Ribble Valley Borough Council  
Housing & Development Control

Your ref: 3/2024/0255  
Our ref: D3.2024.0255  
Date: 19<sup>th</sup> June 2024

Application no: **3/2024/0255**

Proposal: **Proposed demolition of four existing buildings and erection of one new single-storey, three-bedroom dwelling with associated parking and landscaping.**

Site plan as proposed 1:500 @ A3

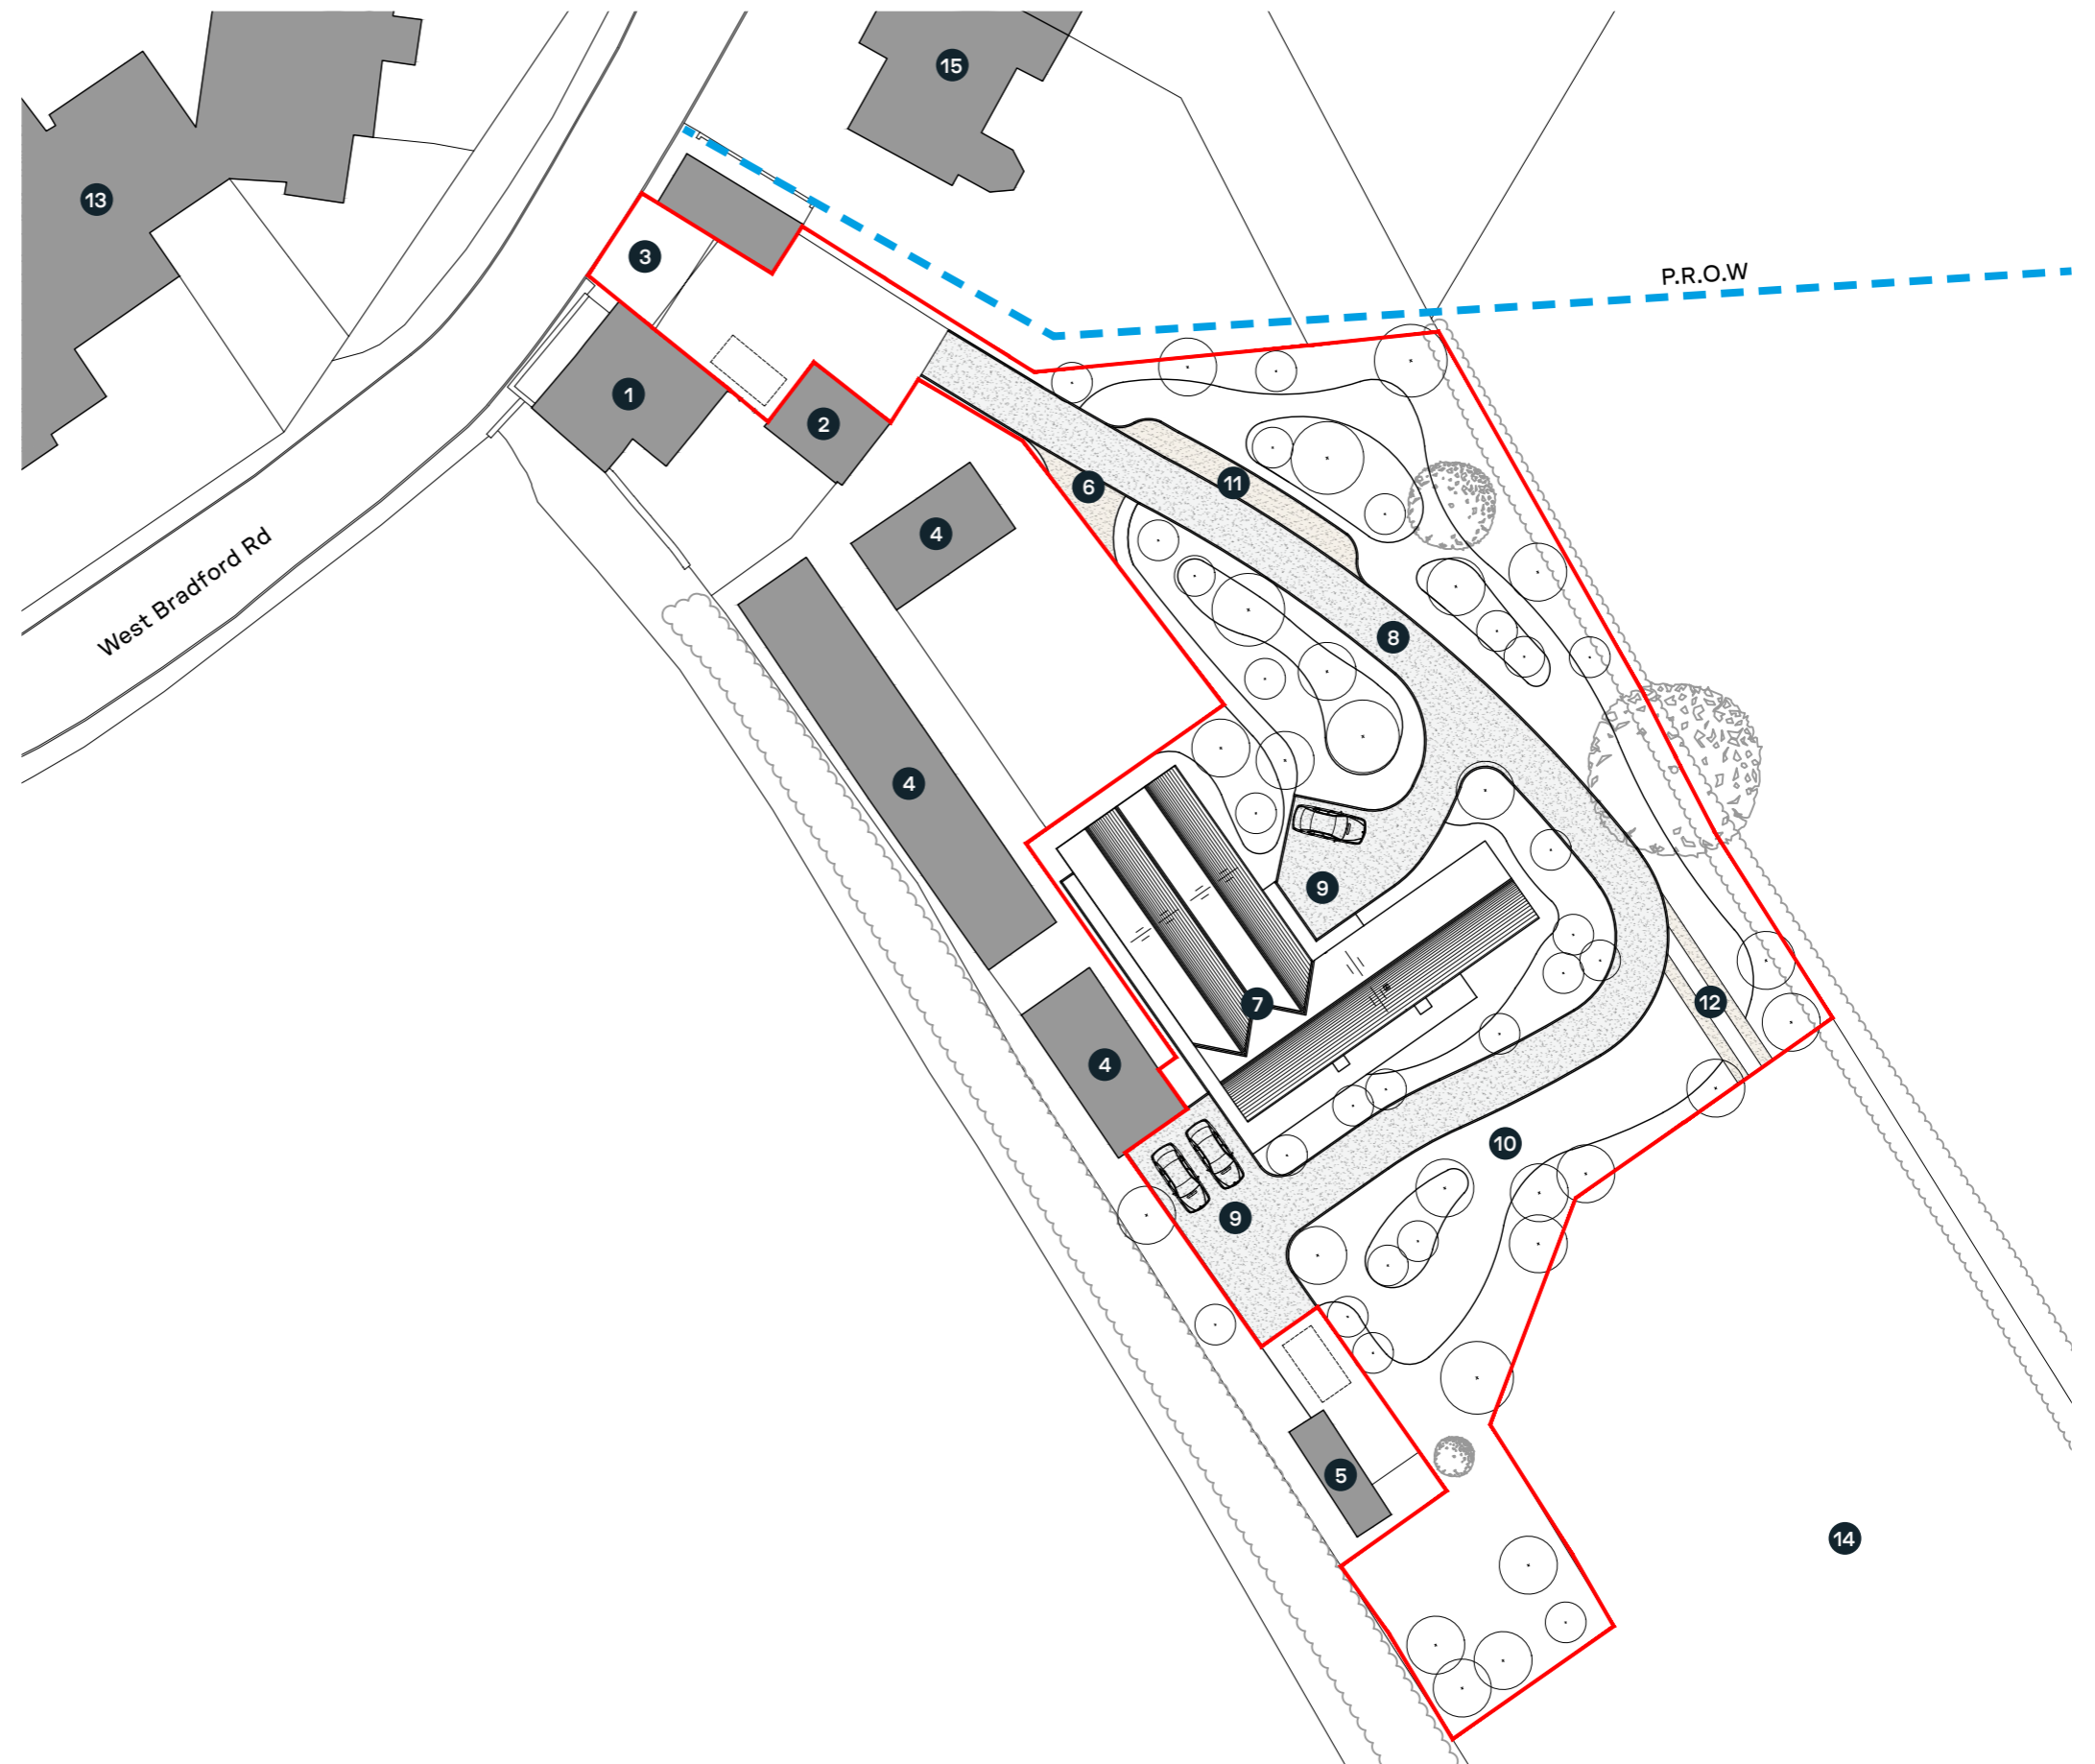
The LHA have reviewed Rural Solutions drawing number 6A\_07 titled "Site Plan As Proposed" and are aware that the existing access will remain unaltered as part of the application. Given that the existing use of the workshop generated trips in its own right and these are likely to be similar to the number of trips which will be generated to the proposed dwelling, the LHA have no further comments to make regarding the site access with the proposal not being seen as an intensification of use.

The LHA have reviewed Rural Solutions drawing number 6A\_07 titled "Site Plan As Proposed" and are aware that 2 car parking spaces will be provided for the 3 bed dwelling which complies with the parking guidance as defined within the Joint Lancashire Structure Plan.

Furthermore, the LHA have reviewed Rural Solutions drawing number 6A\_07 titled "Site Plan As Proposed" and are aware that the proposal is aiming to formalise an access track which will serve the site. The proposed access track which connects to the site access and serves the agricultural field, two dwellings (including the one proposed) and a number of buildings which are used for light industrial, will be 3.5m wide which complies with the LHAs guidance. The LHA also welcome the introduction of a passing place along the track.

2. No part of the development hereby permitted shall be occupied until such time as the access and access track arrangements shown on Rural Solutions drawing number 6A\_07 titled "Site Plan As Proposed" have been implemented in full.

3. The development hereby permitted shall not be occupied until such time as the parking and turning facilities have been implemented in accordance with Rural Solutions drawing number 6A\_07 titled "Site Plan As Proposed". Thereafter the onsite parking provision shall be so maintained in perpetuity.
